1 March 2013

RE: Submission to MP09_0066 MOD 6 Thomas Street Carpark, Chatswood

Please consider this letter of objection to the above modification application.

BUILDING 1
ELEVATION - EAST
A-0123
SECTION 75 W SUBMISSION

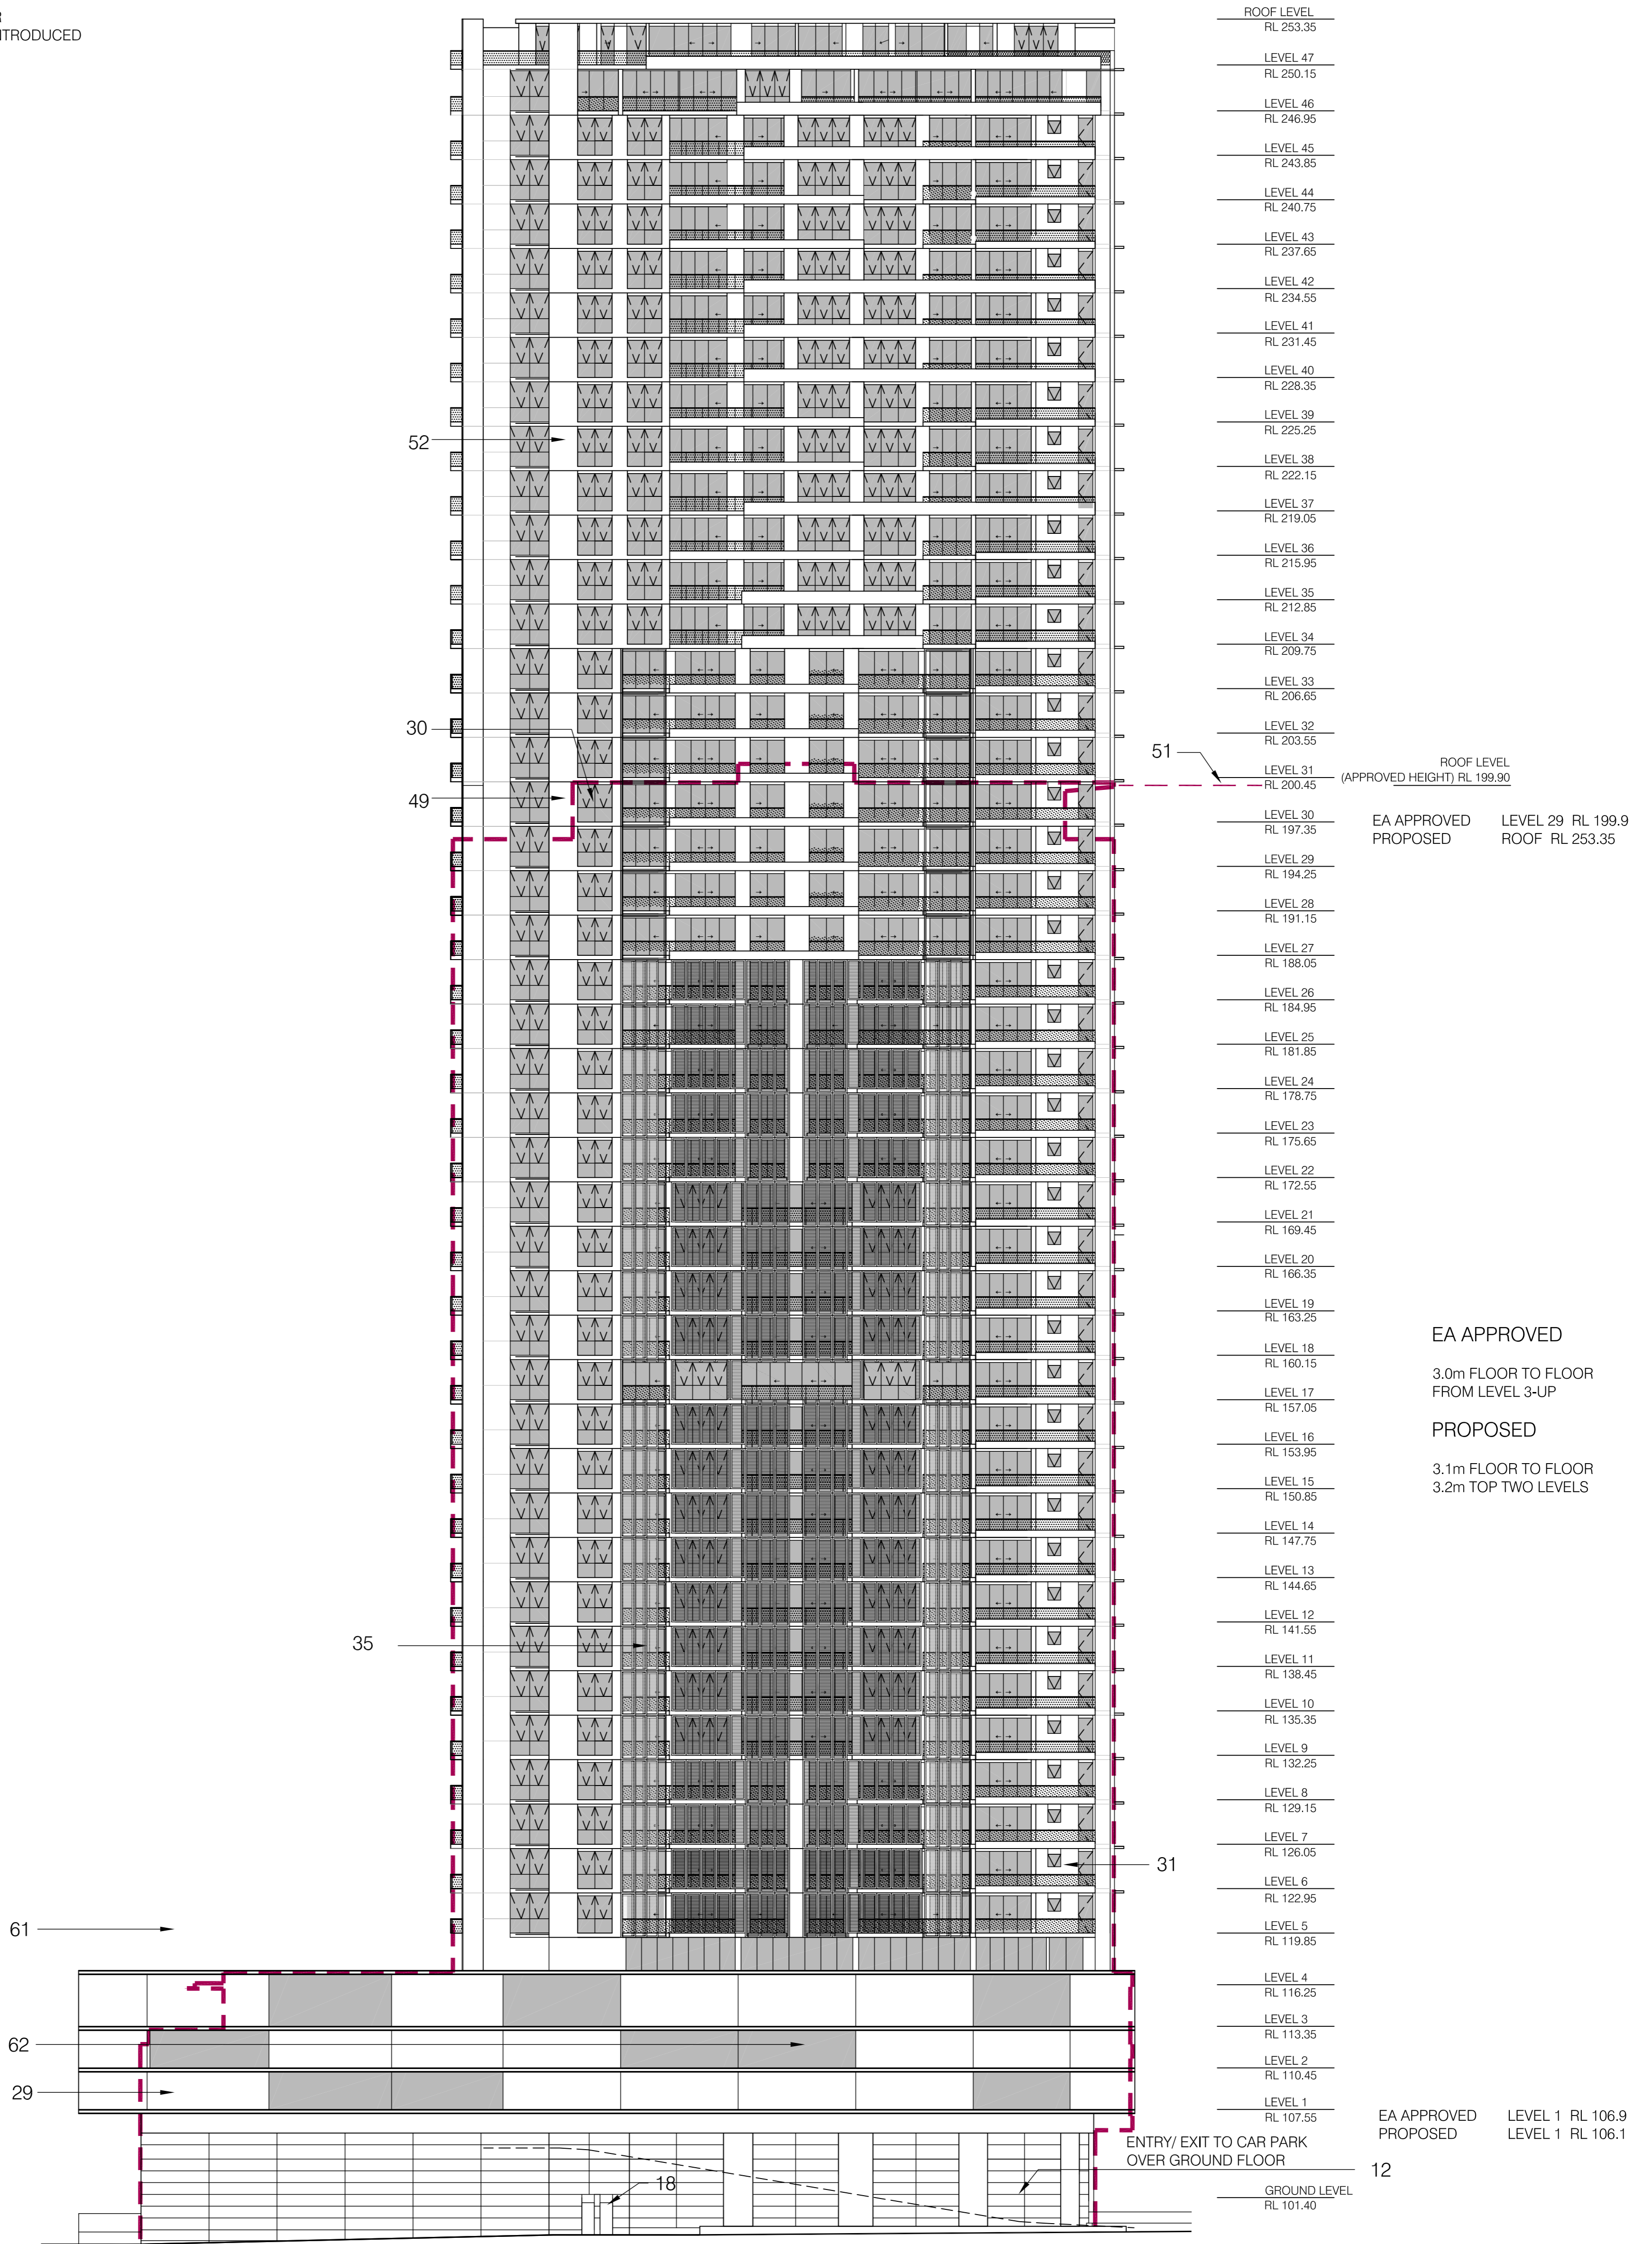
**Lowering of the height of the cantilevered floors over the ROW and the increase in size of the Residential tower that will mean a decrease in distance of the Residential Tower to 12 Thomas Street.
Objection to Building 1 - Setback to 12 Thomas St.**

I strongly object to the proposed modification to lower the height of the cantilevered floors of the Meriton Residential Tower over the ROW – as it is the Meriton Building will dwarf 12 Thomas Street and will adversely affect natural sunlight , my view . The building will be a monstrosity with a claustrophobic presence. It is my understanding that the cantilever over the ROW has been approved to start at approximately the height of level 4 or 5 of 12 Thomas Street which will allow for some respite (distance) from the residential tower if

I object to the proposed lowering of the cantilever floors over the ROW which will essentially make the ROW a dark unlit tunnel posing danger to pedestrians and the disabled. Being a medical building we have many sick people requiring access so I also have concerns over traffic fumes and ventilation in the ROW and any access fumes that will be trapped between the buildings affecting the quality of air for not only people walking through the ROW but also in my studio which is located on the 4th floor of 12 Thomas St western side.

BUILDING 2
ELEVATION - EAST
A-0124
SECTION 75 W SUBMISSION

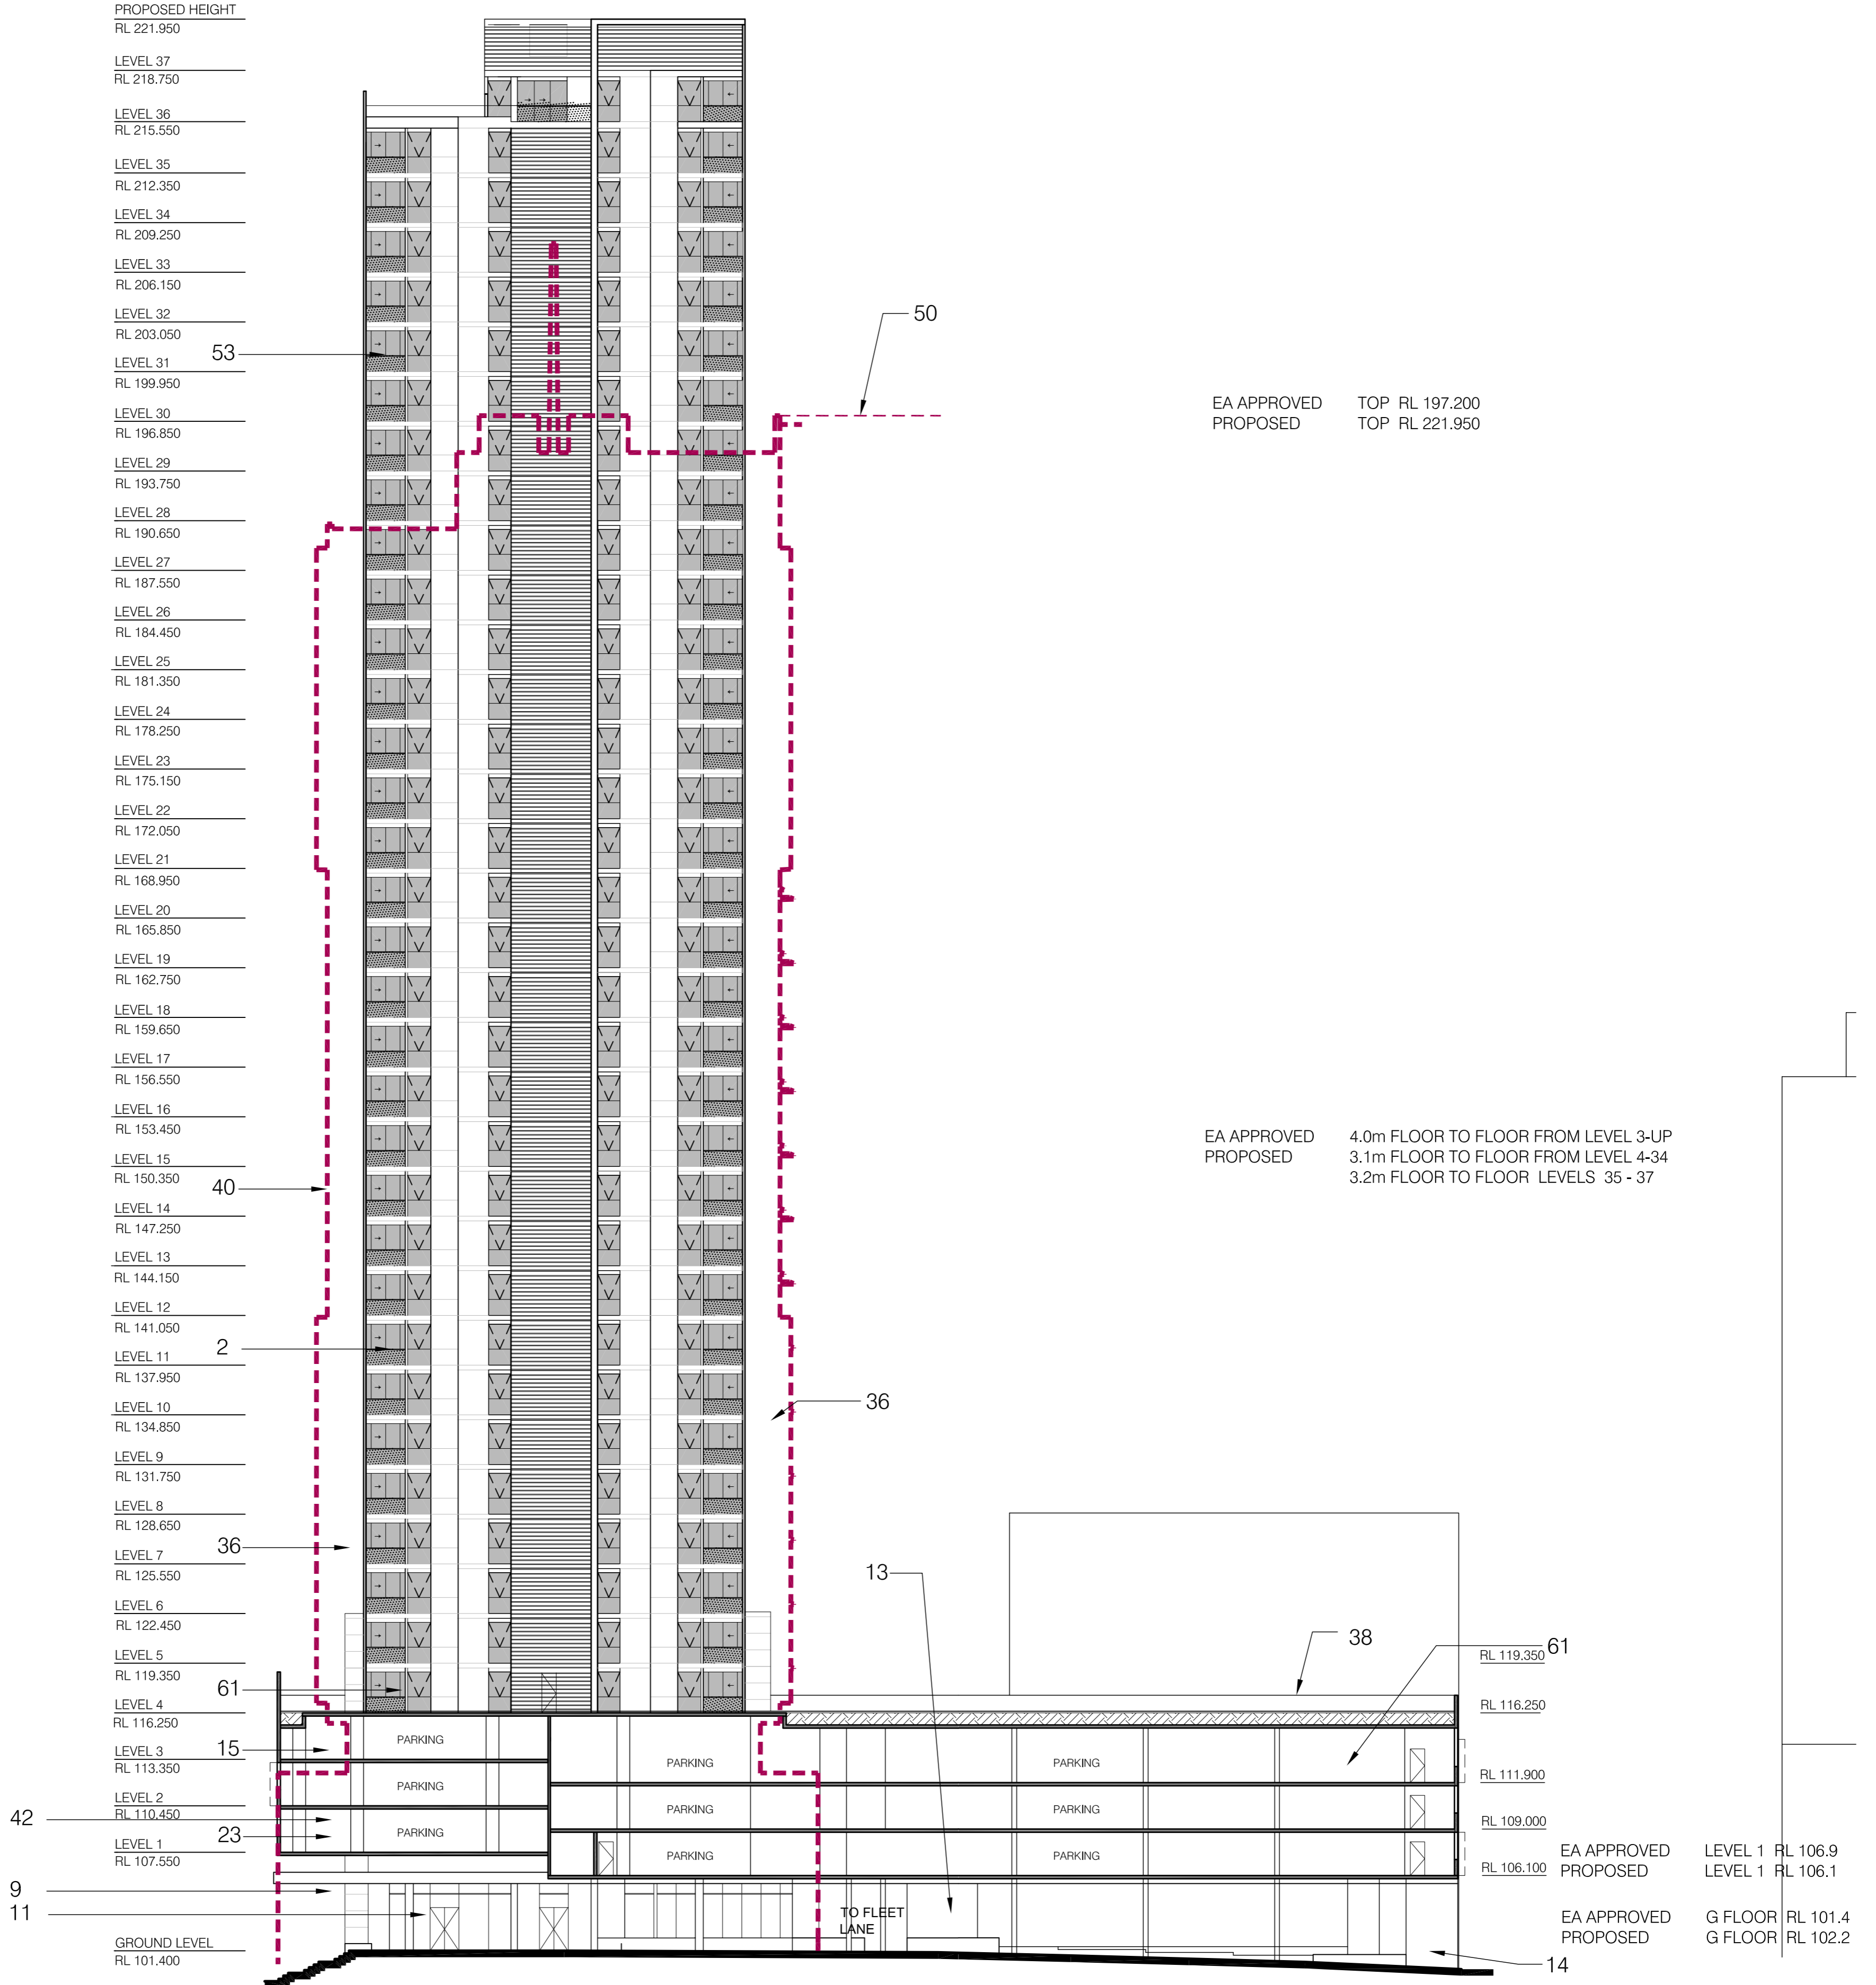
I object to changing building 2 from commercial use to serviced apartments. There is not enough commercial space in the Chatswood, and most of this space is aging and lacking in disability access and/or after hours access. There is not much to draw business to Chatswood and take advantage of the public transport hub and provide job opportunities for the escalating number of people that will be living in all of the apartment buildings in Chatswood.
